KITTITAS COUNTY FIRE MARSHAL'S OFFICE

October 10, 2016

Re: Mitchell (BL-16-00013)

**CRUSE & ASSOCIATES**  
 PROFESSIONAL LAND SURVEYORS  
 217 East Fourth Street P.O. Box 959  
 Ellensburg, WA 98926 (509) 962-8242  
**MITCHELL PROPERTY**

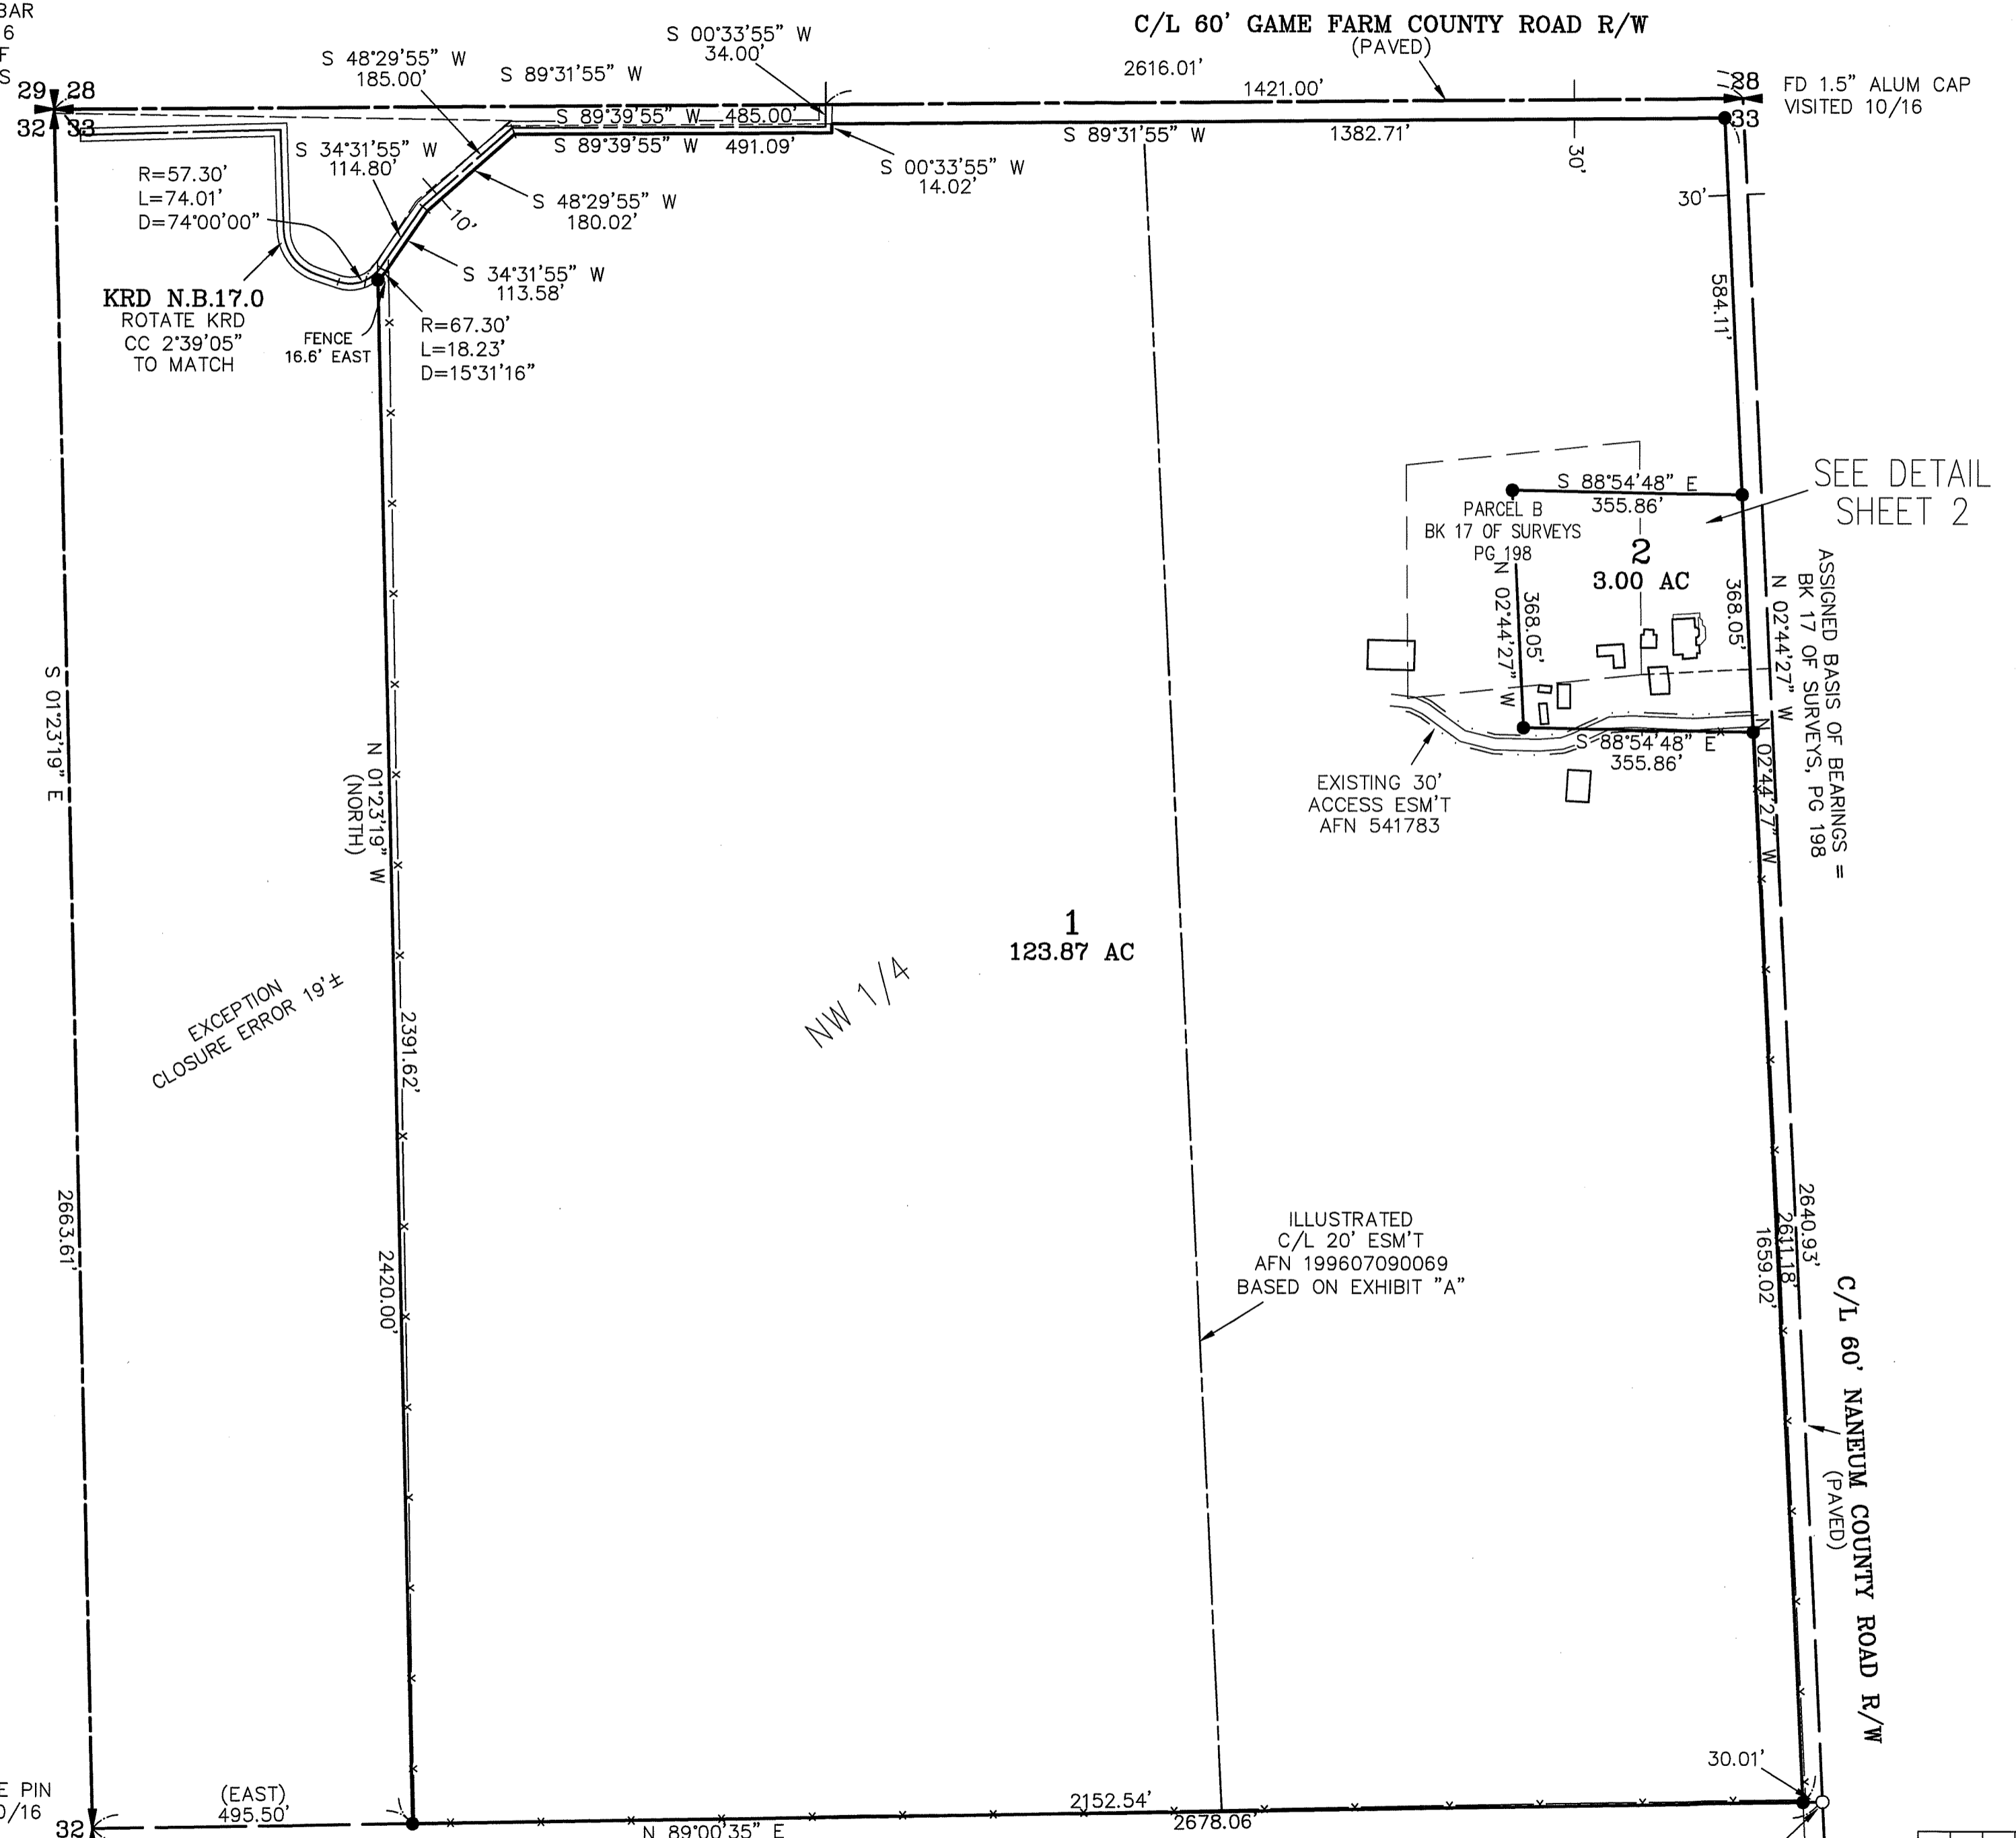
- Ensure that boundary line adjustments do not infringe upon existing structures, to include propane tanks, etc.
- Ensure adequate access for fire apparatus. Any driveways or access points created based off the new lot configurations shall comply with Kittitas County Code 20.02.030.
- All future development must comply with the International Fire Code.
